Matter raised during the Open Floor Hearing (OFH1 – 30th September 2022) by Boreham Parish Council (Cllr Linda Reed) relating to the increased levels of traffic on the 2 country lanes which are the only access routes to the proposed entrance of the Longfield Solar Farm.

Contains Ordnance Survey data © Crown copyright and database right 2020

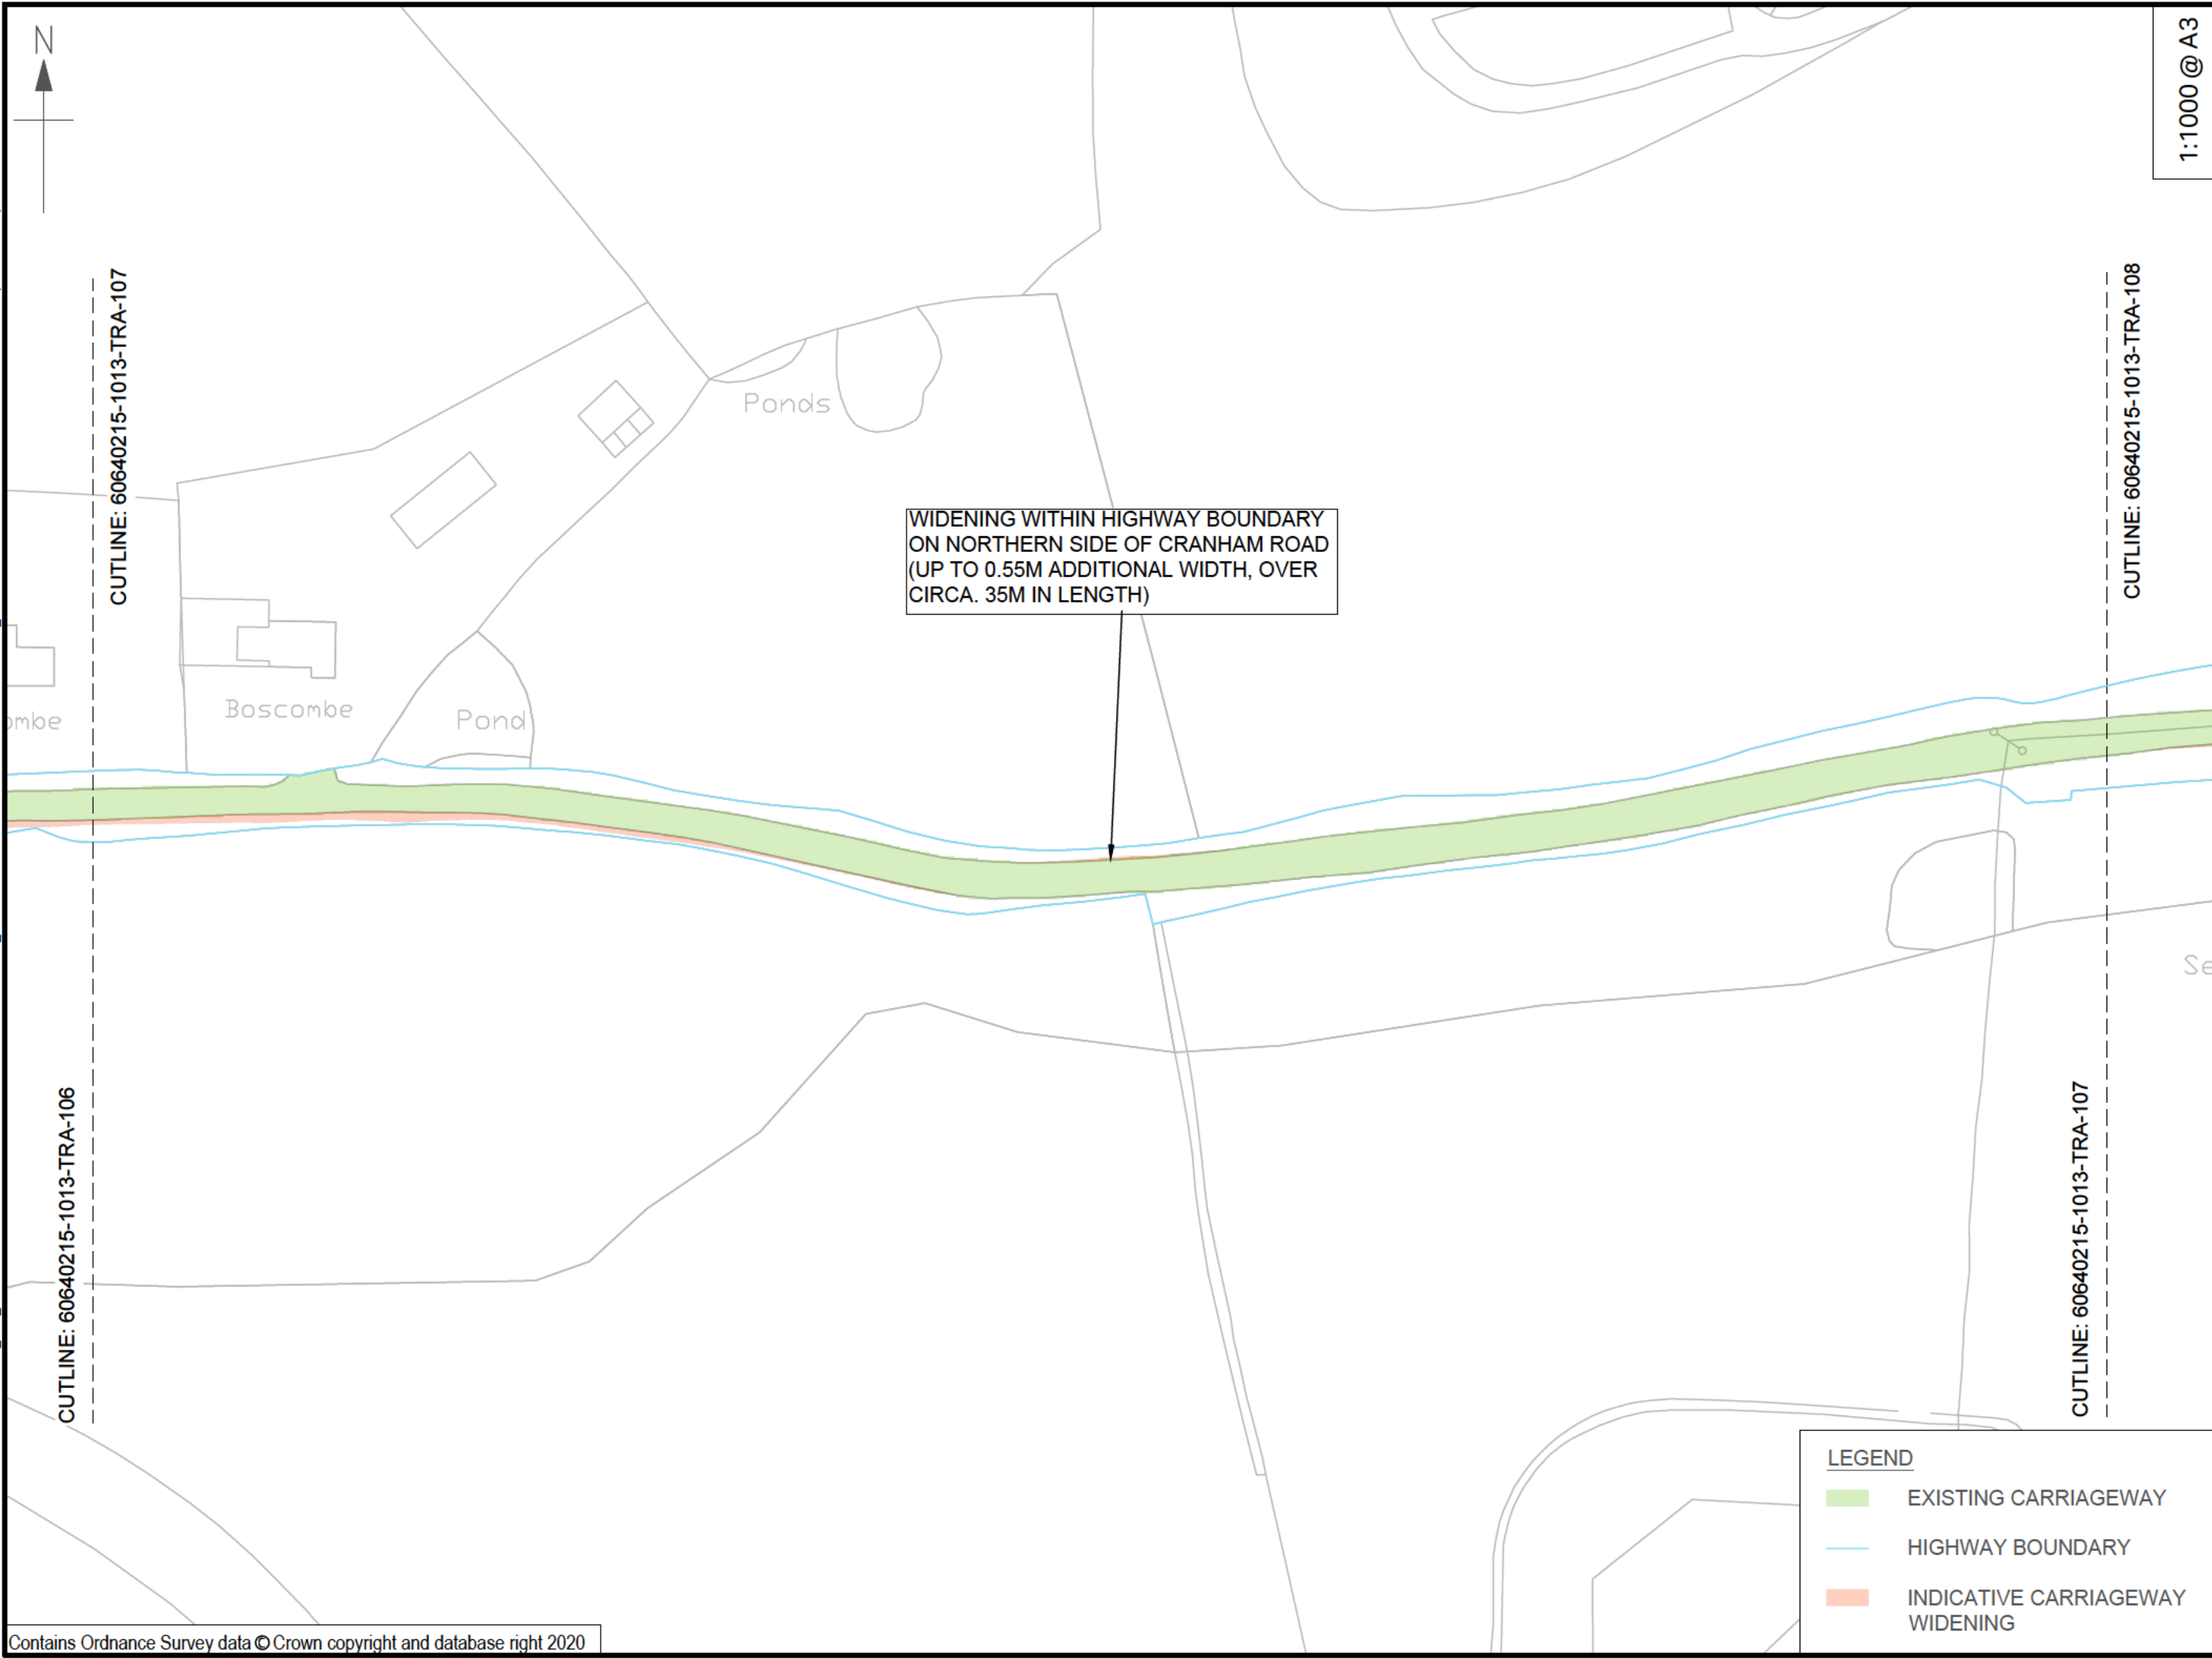
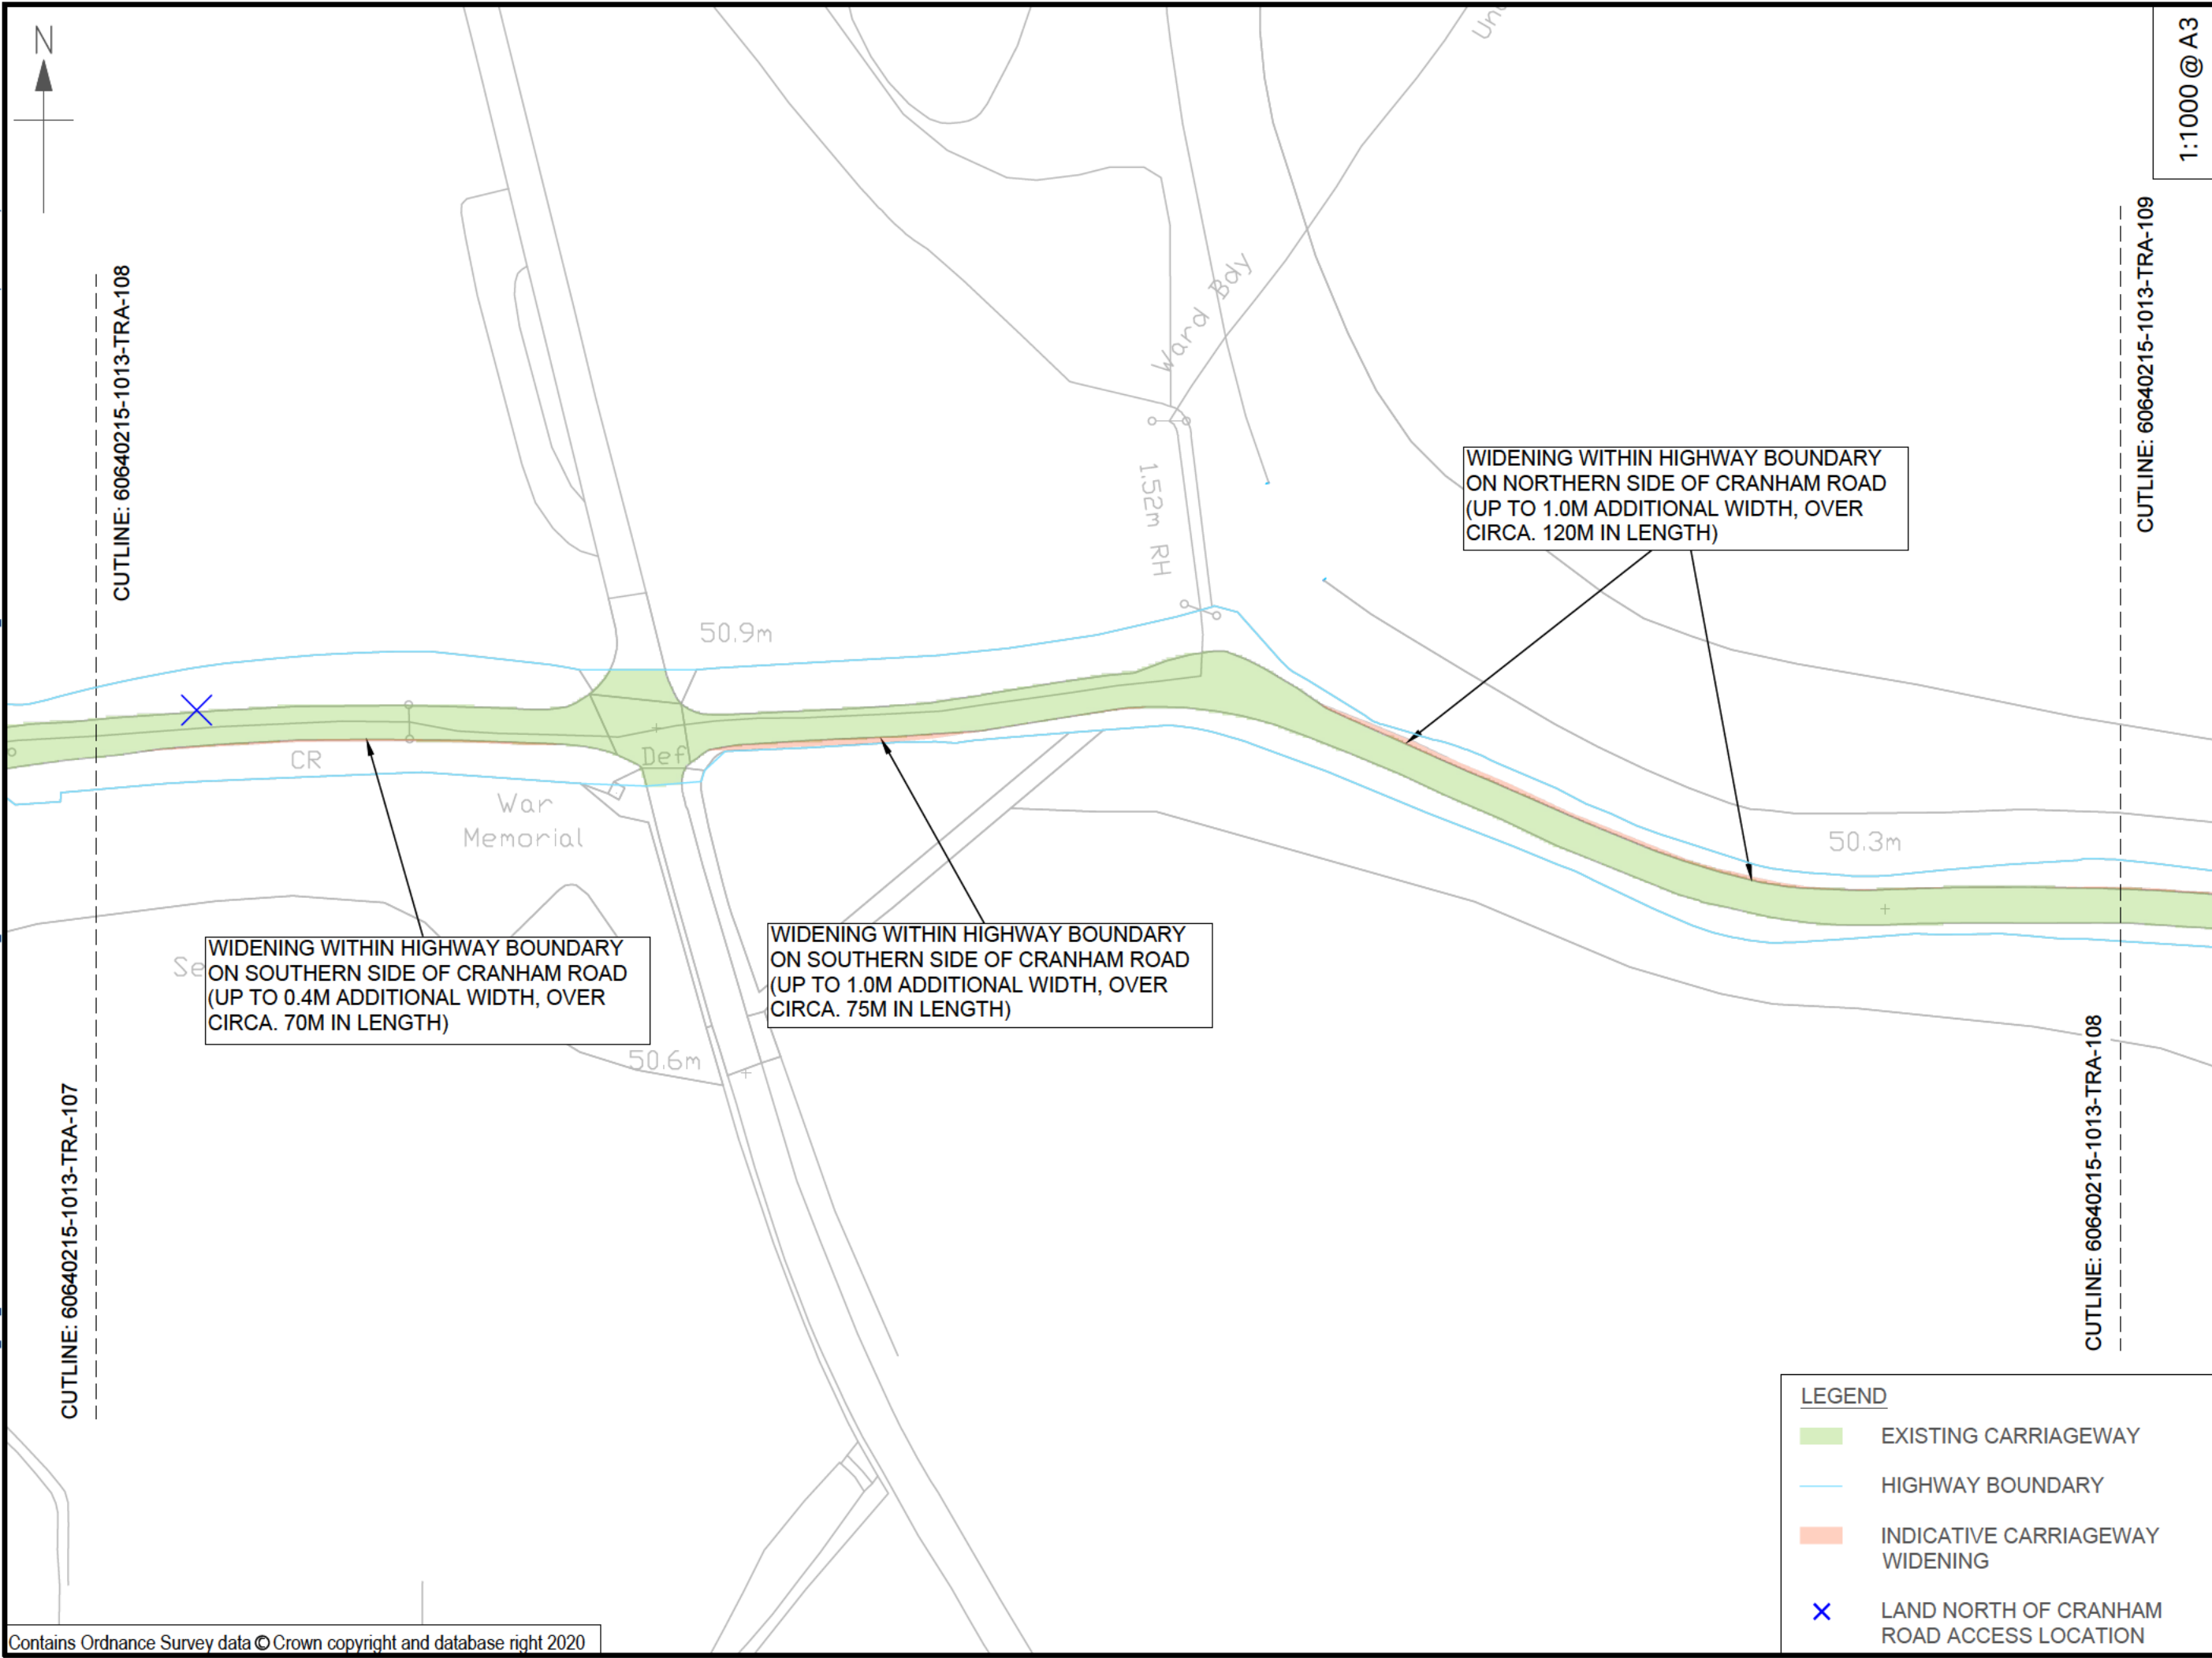
The developer's preferred route to the Longfield site is via Cranham Road and Wheelers Hill. This is country lane which, even following the proposed widening is not deemed suitable for the type traffic anticipated during the implementation phase at Longfield. This route will also be impacted by the construction of the Chelmsford North East Bypass (CNEB). The only other route to the site is via Main Road, Boreham and Waltham Road. It is the stated intention of the developer not to use this route. However, it is likely that there will be times throughout the implementation phase and beyond where this will be necessary due to blockage, delay or temporary closure affecting the preferred route or other routes leading to it. These incidents do occur from time to time.
